Proposed Development

The proposal is for the removal of the low-pitched roof over the rear extension to be replaced with a flat roof terrace. The terrace will be bound by a glass balustrade partly obscured. Access to the terrace will be by the erection of an external staircase.

Recommendation

Approve with conditions.

Proposed Site

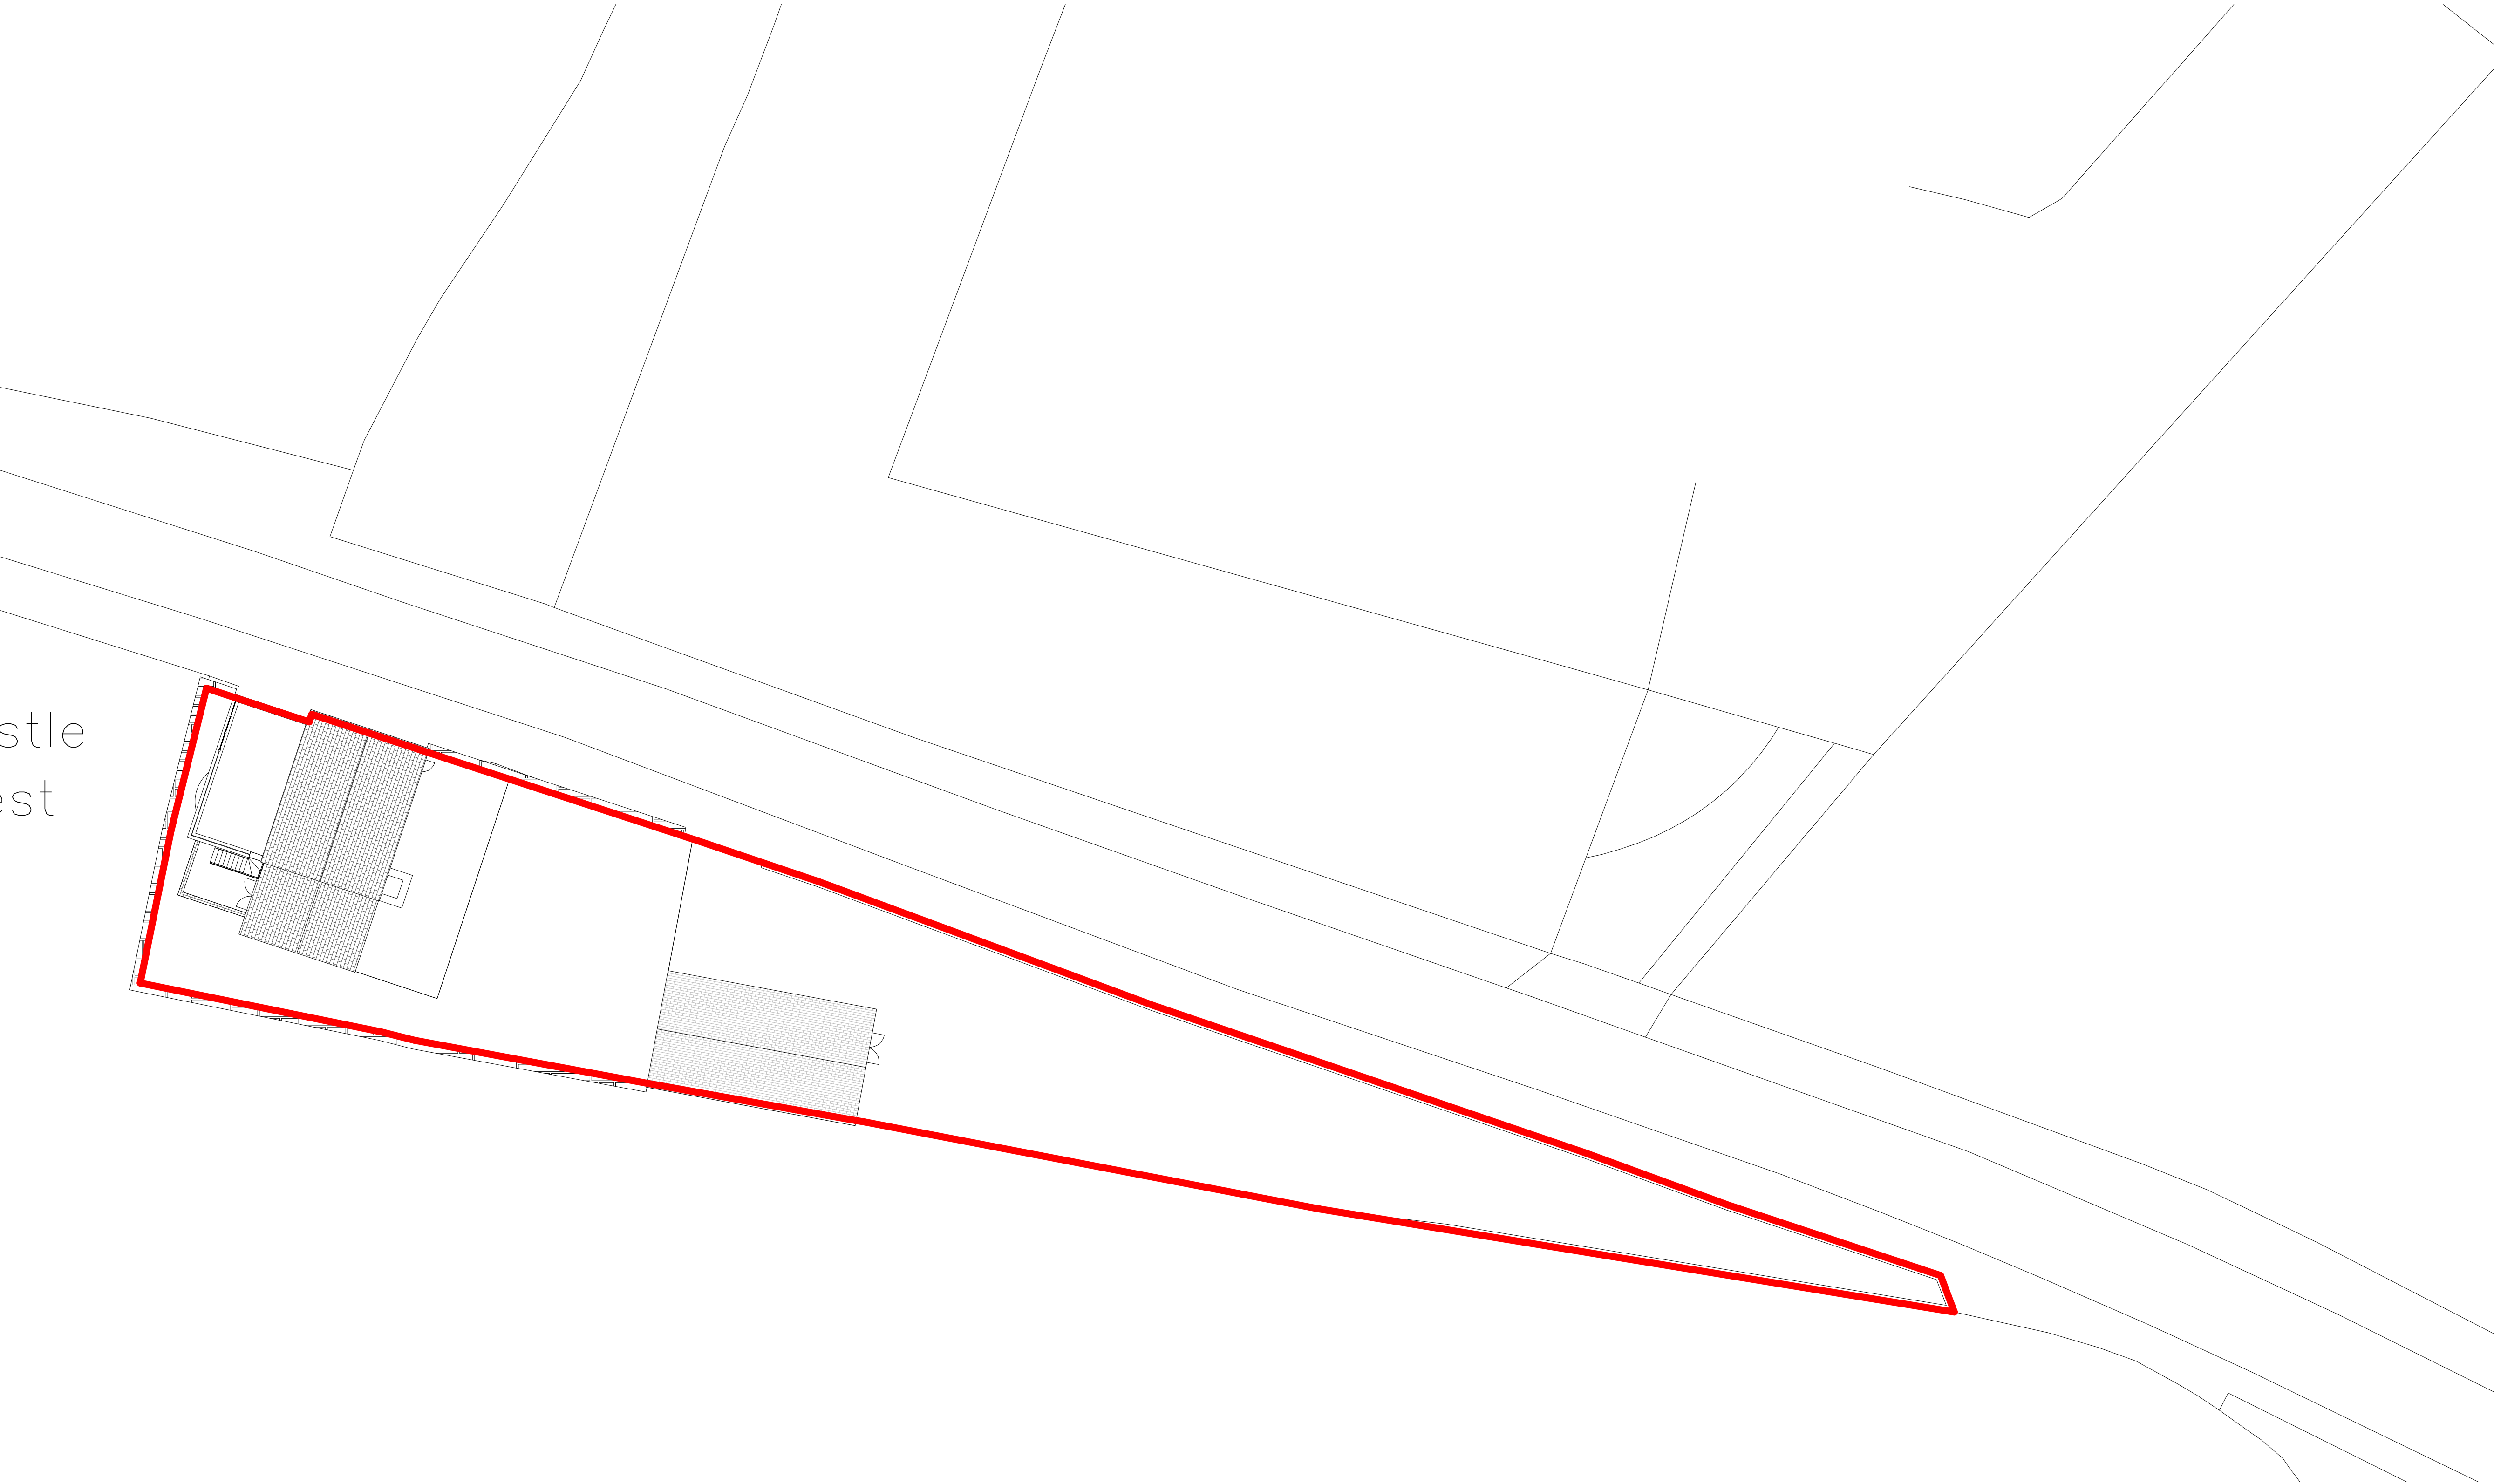
The assessment in terms of impact to the Green Belt has been made. The proposed extensions are relatively small in size. The proposed extensions result in 109% of the Green

Belt allowance used. As the extensions are well within the boundary of the site and exceed marginally over the 100% allowance, given the nature of the proposals and what could be erected under permitted development, the proposals are acceptable in terms of impact to the Green Belt.

Title
Proposed Elevations

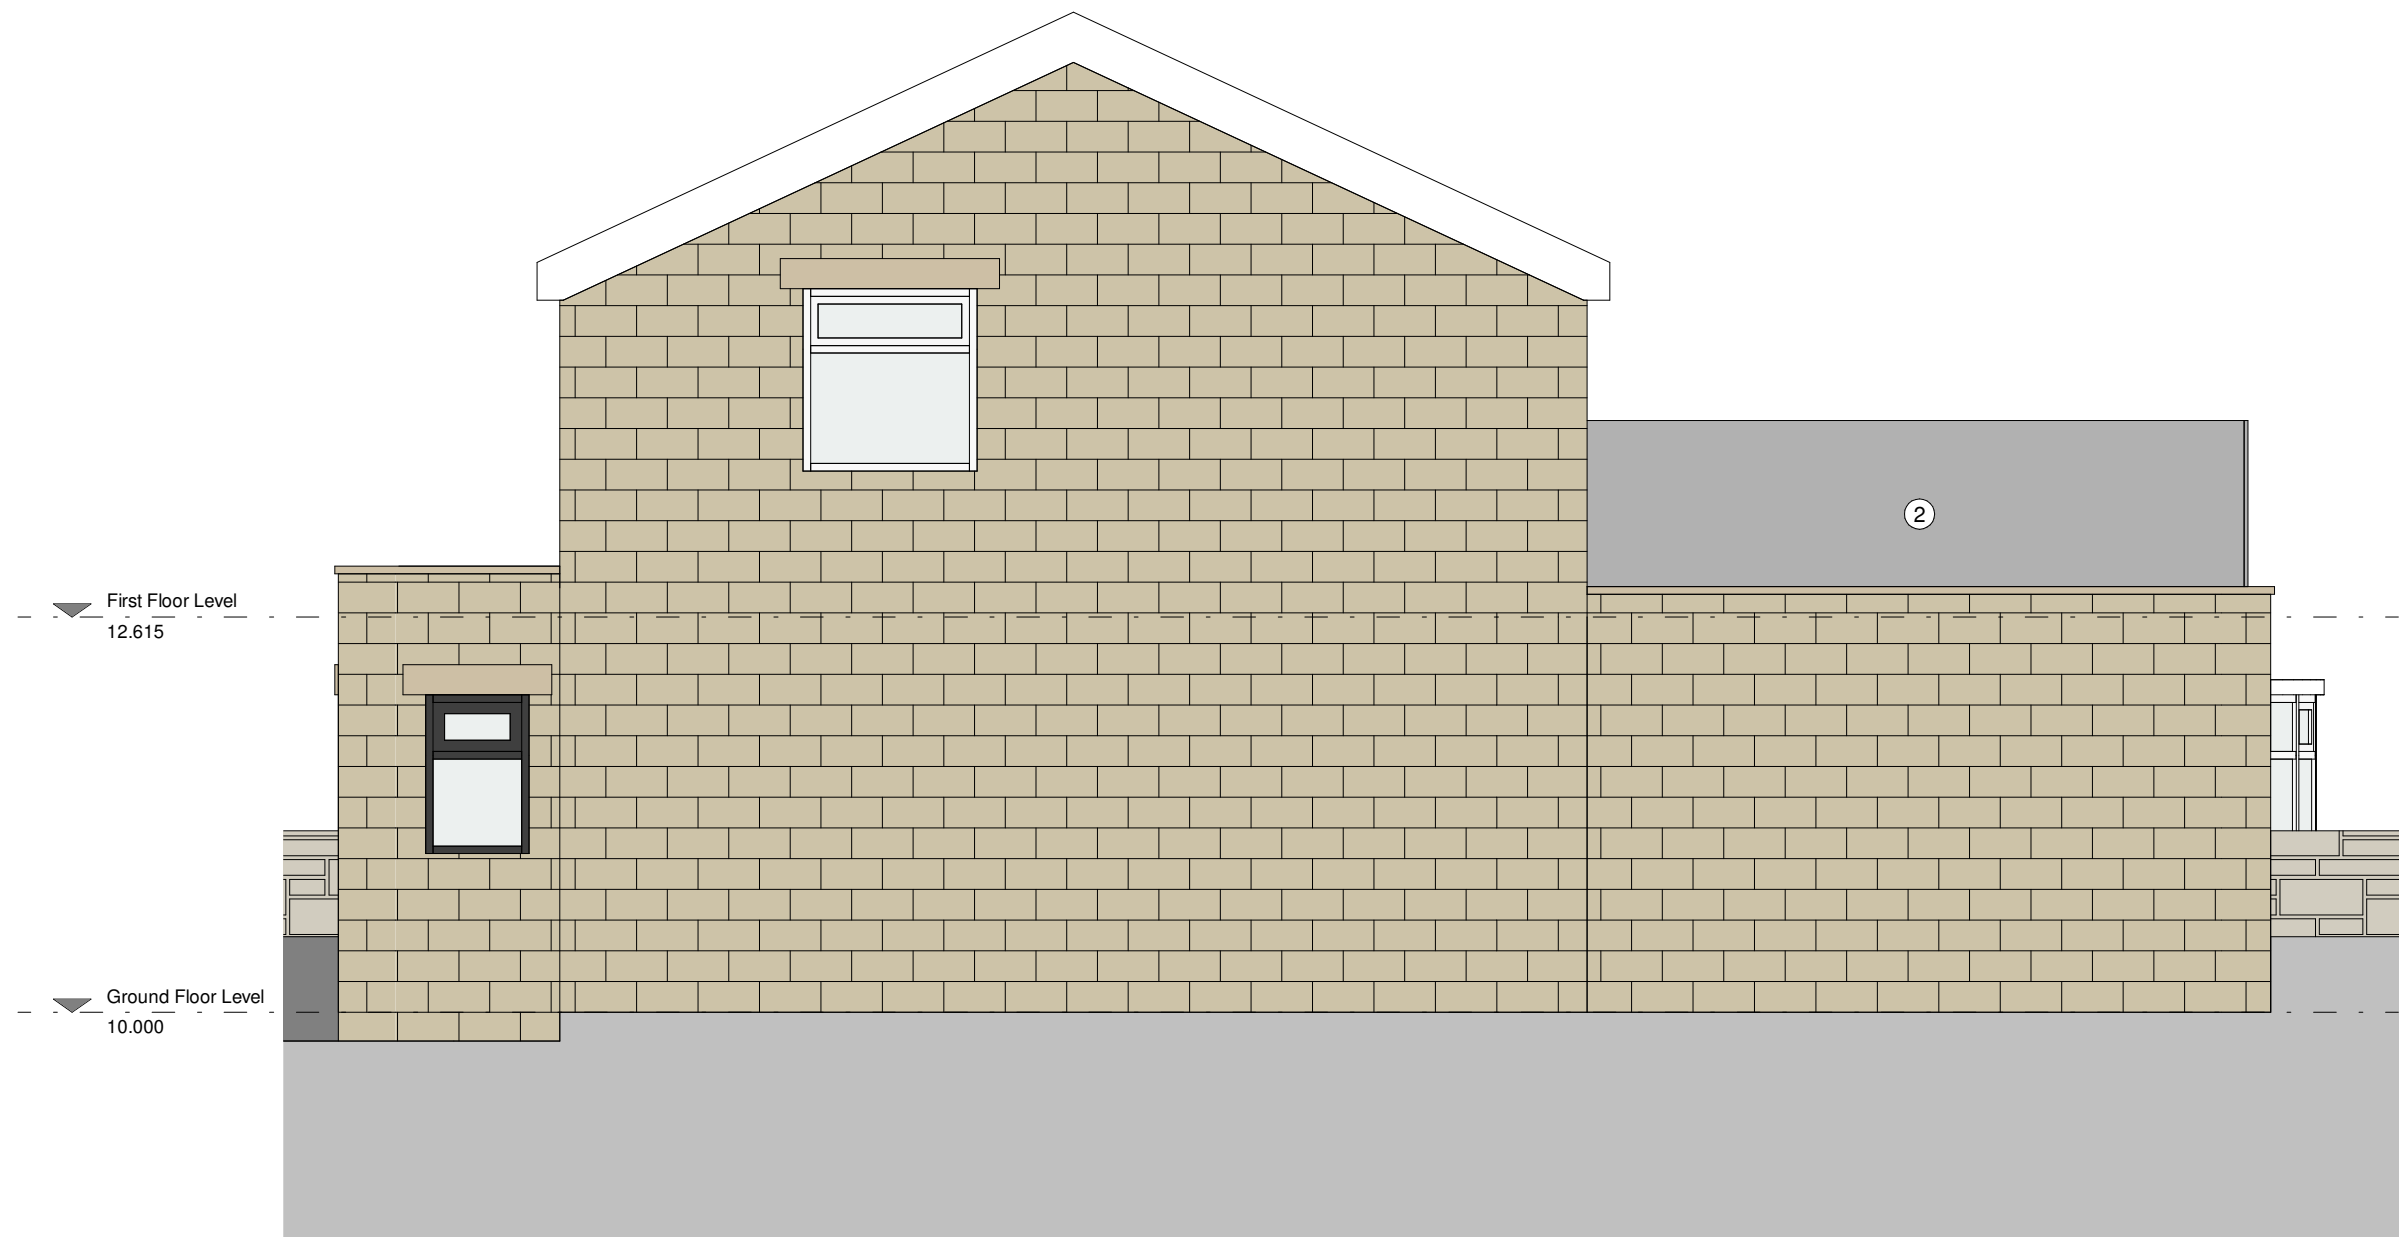
The proposed staircase will be constructed in stone to match the existing property. The balustrade will be glazed which is not expected to severely impact the visual appearance of the host property.
